SCOPING OPINION:

Proposed Able Marine Energy Park (AMEP) Quay Material Change 2 Application

Case Reference: TR030006

March 2021

Proposed Footpath up to Agricultural Crossing

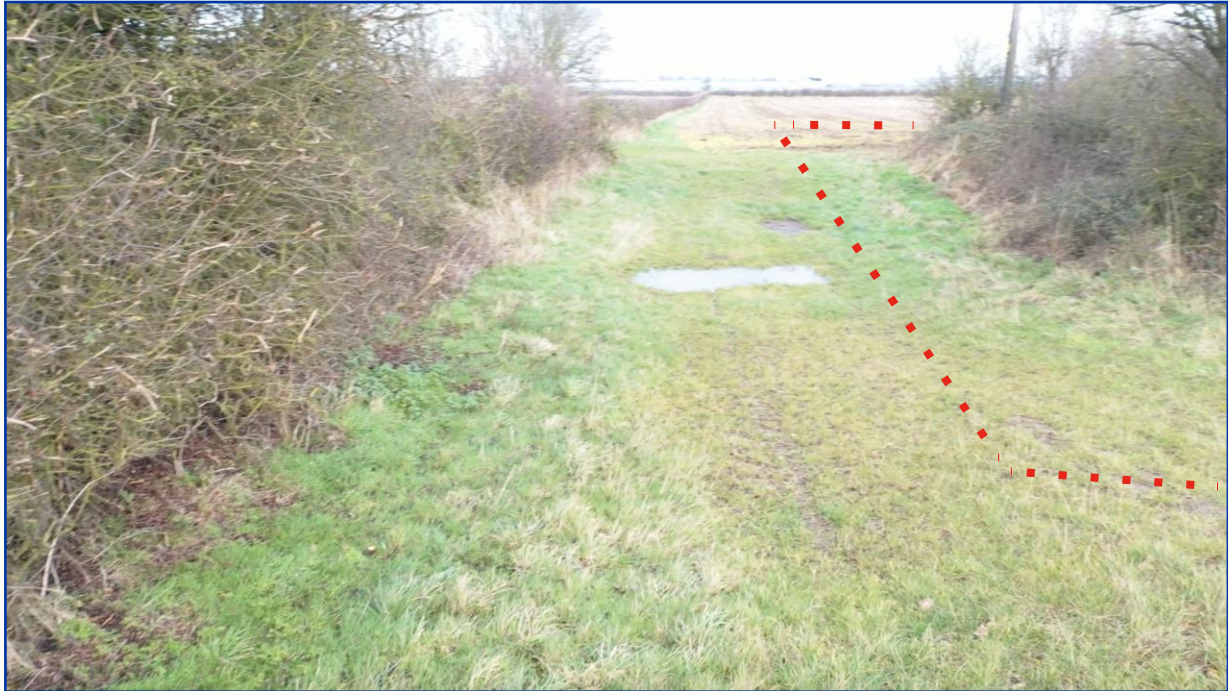
- to construction methods in the terrestrial development area
 - to the arrangements for parking as detailed on the consented Indicative Masterplan.
- 2.3.3 The proposal includes a diversion of Footpath 50 which would result in a change to the length of the route. The proposed footpath diversion is shown in Drawing AME-036-00004 in Appendix 1.
